Your Ref: 2015/62/92343/E  
Our Ref: R012287

8th September 2015

**Warwick Mills, Warwick Road, Batley - Part demolition and conversion of mill to form 18 residential units**

**Drawing Number:**  
 14-256 -05

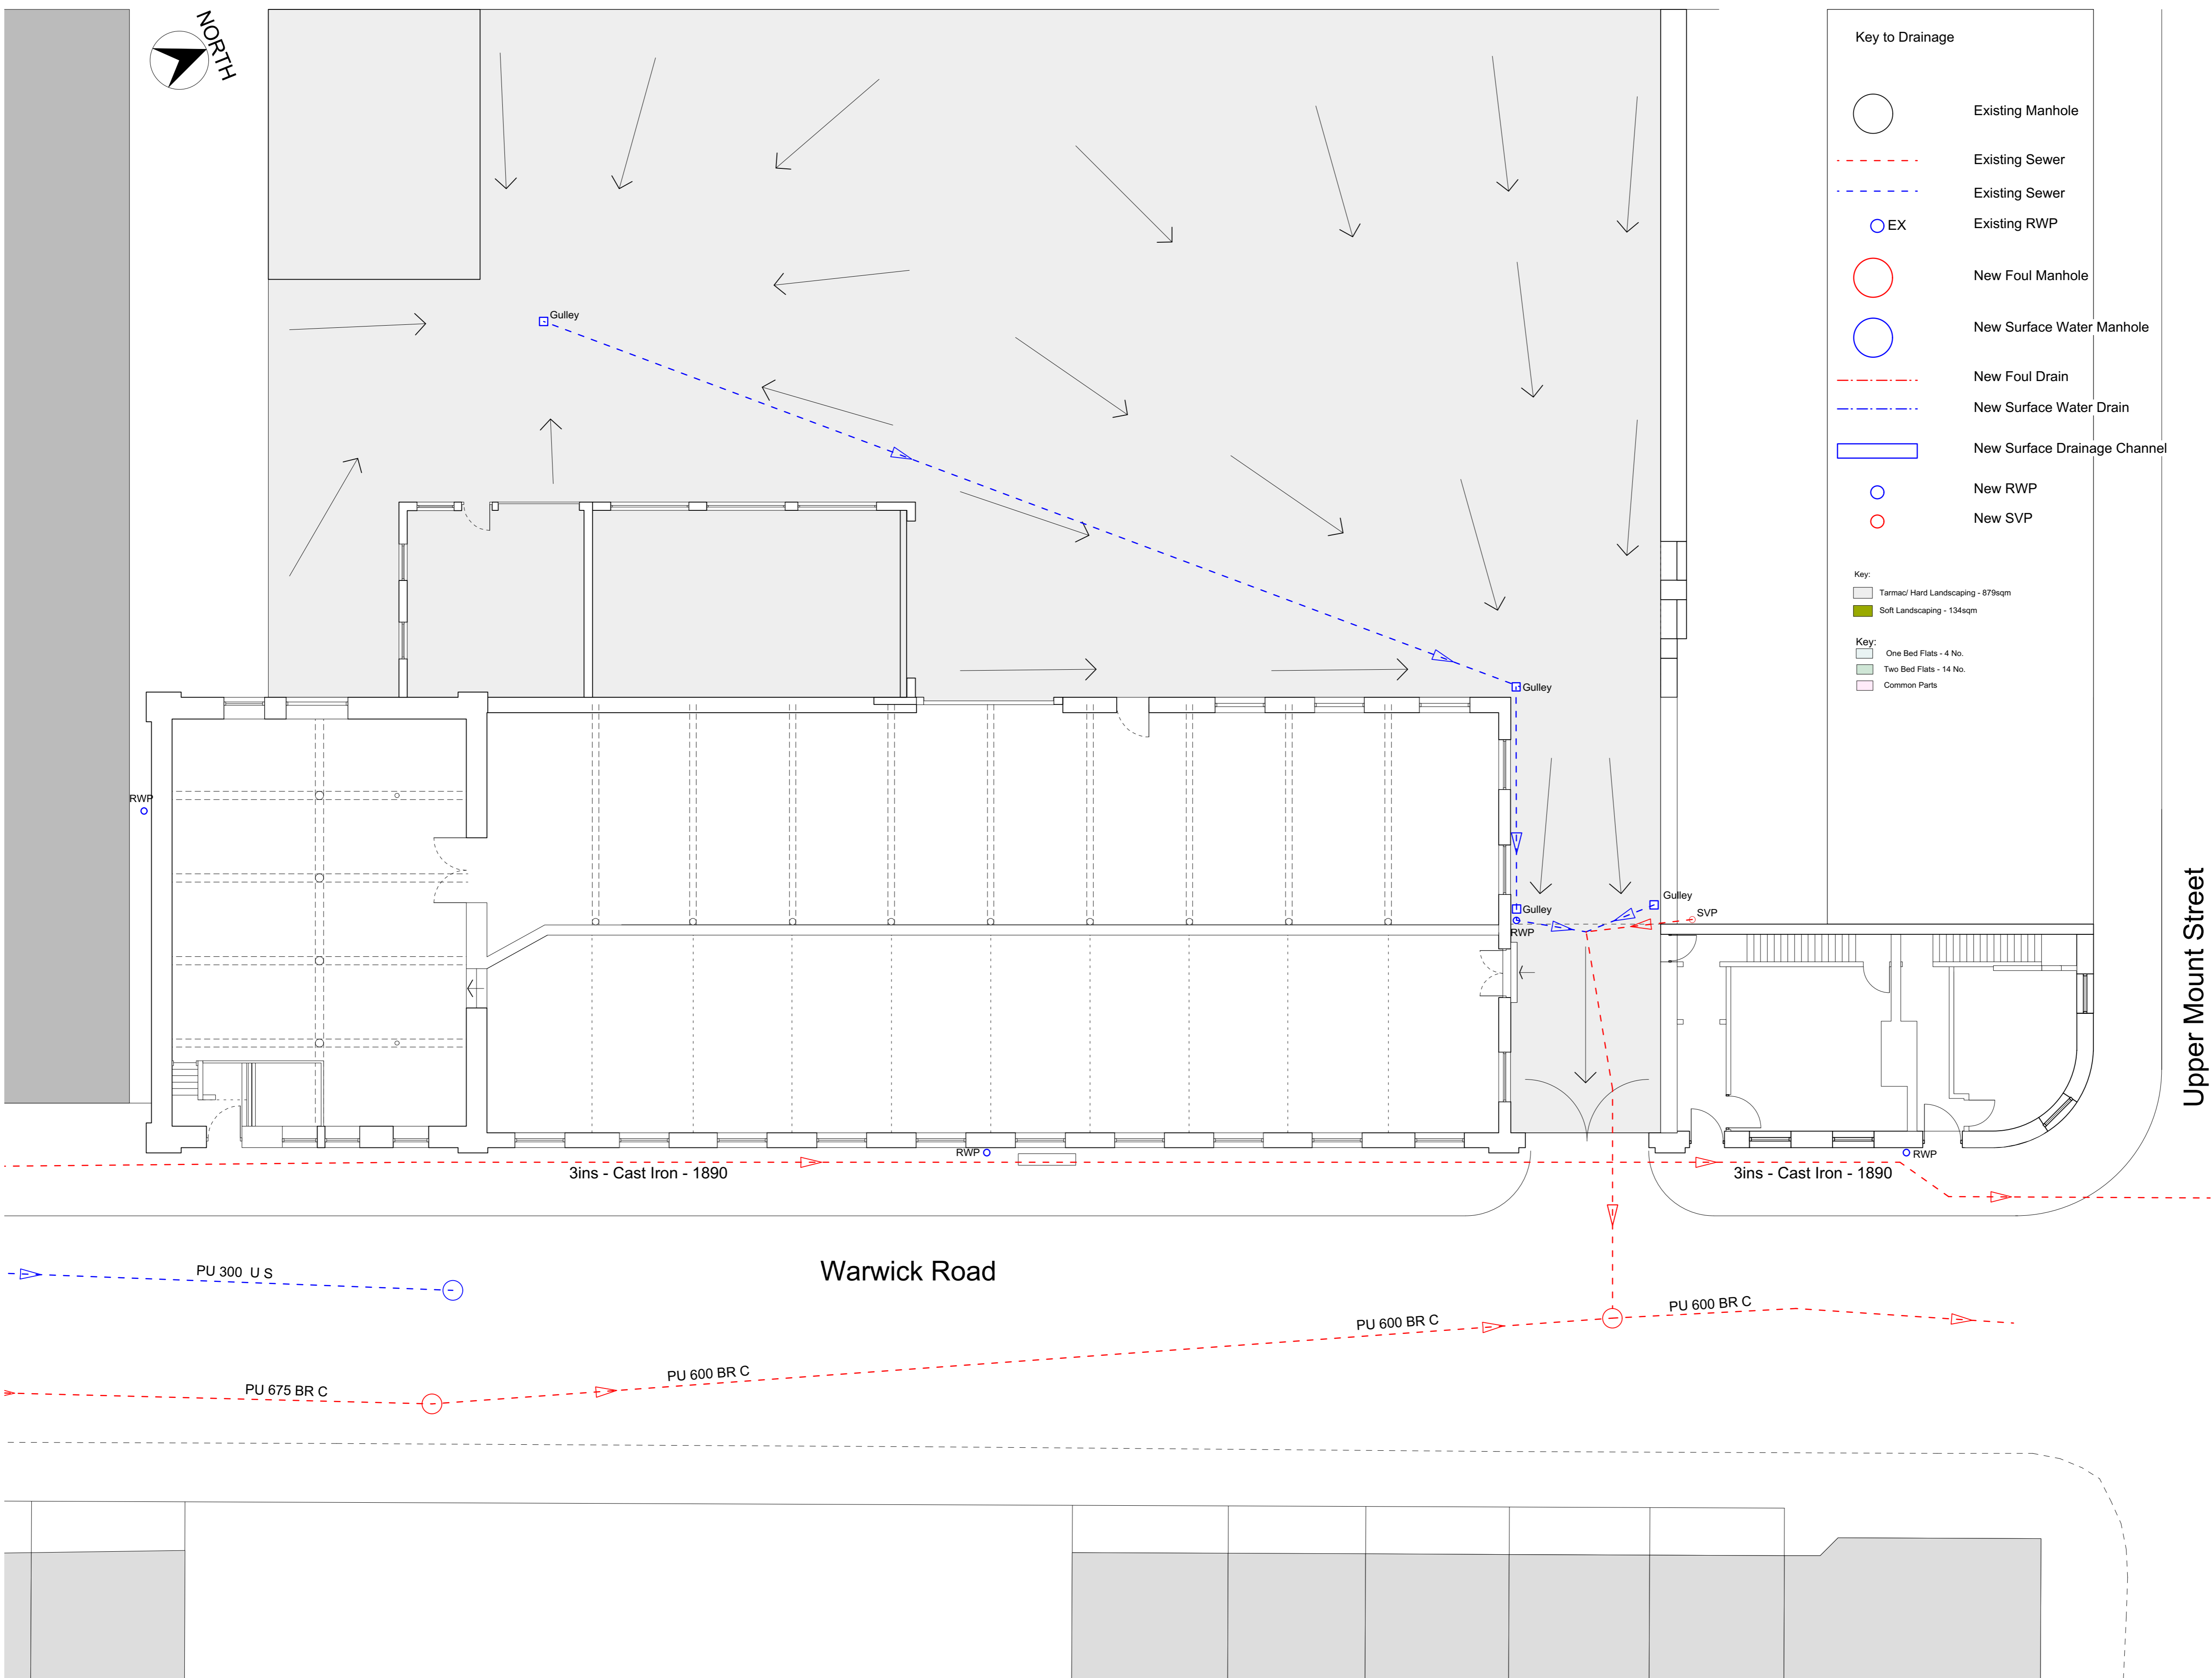
The drainage details submitted on drawing 14-256-10 dated 12/02/2015 that has been prepared by RIBA are not acceptable to Yorkshire Water as currently shown. The following point should be addressed. For further information, the developer should contact our Developer Services Team (telephone 0345 120 84 82):

- i) The Drainage Impact Assessment (Revision A dated February 2015) indicates; the impermeable area of the 'new build' will be reduced to 879m<sup>2</sup> from that of the existing (996m<sup>2</sup>), therefore, surface water run off will be reduced, however, the developer should provide evidence of existing positive drainage to a public sewer from the whole red line site boundary to the satisfaction of YWS/the LPA by means of physical investigation. On-site attenuation, taking into account climate change, will be required.
- ii) The submitted drawing should show surface water storage and flow control rate.

**No development shall take place until details of the proposed means of disposal of surface water drainage, including details of any balancing works and off-site works, have been submitted to and approved by the local planning authority. Furthermore, unless otherwise approved in writing by the local planning authority, there shall be no piped discharge of surface water from the development prior to the completion of the approved surface water drainage works. (To ensure that no surface water discharges take place until proper provision has been made for its disposal)**
